Recommendation Report for Planning Permission for Works or Extension to a Dwelling

REF NO: M/103/25/HH

LOCATION: 22 South Walk
Middleton-on-sea
PO22 7RN

PROPOSAL: Single storey front extension and alterations to fenestration, following demolition of existing conservatory.

PROPOSED GROUND FLOOR PLAN 1:100

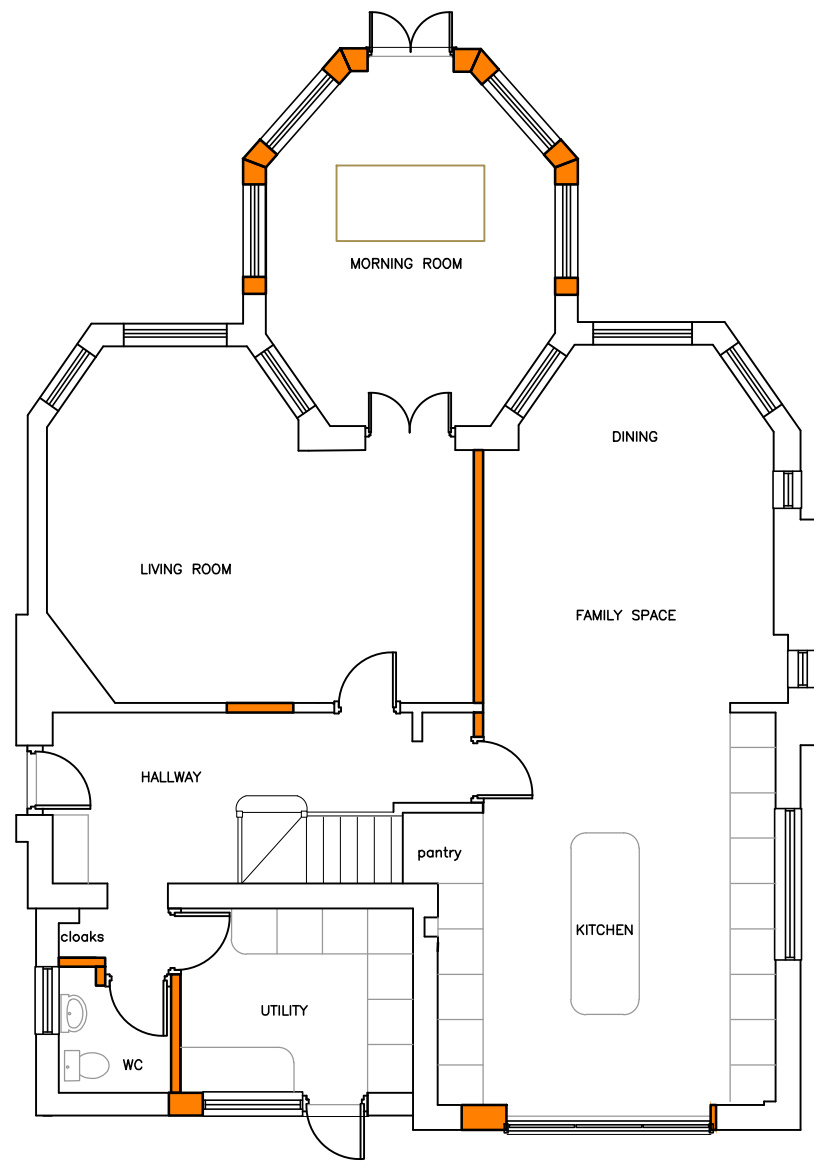
The single storey front extension would have a flat roof, at 3.3m high, 0.2m less than the existing conservatory. The extension would have a rooflight within the flat roof. The extension would be equal in width and depth to the existing conservatory and would mirror the form of the existing bay windows to create an octagonal shaped room. Full length windows are proposed to maintain the glazed frontage. The extension would be accessed via doors on the south elevation, rather than on the east elevation as existing. The extension would be constructed from painted rendered block work and would be a subservient addition to the host dwelling and in keeping with the varied character of the area.

In this instance, the extension would be constructed over an area of existing hard standing (replacing an existing conservatory) and would not result in an increase in impermeable or hard surfaces within the application site.
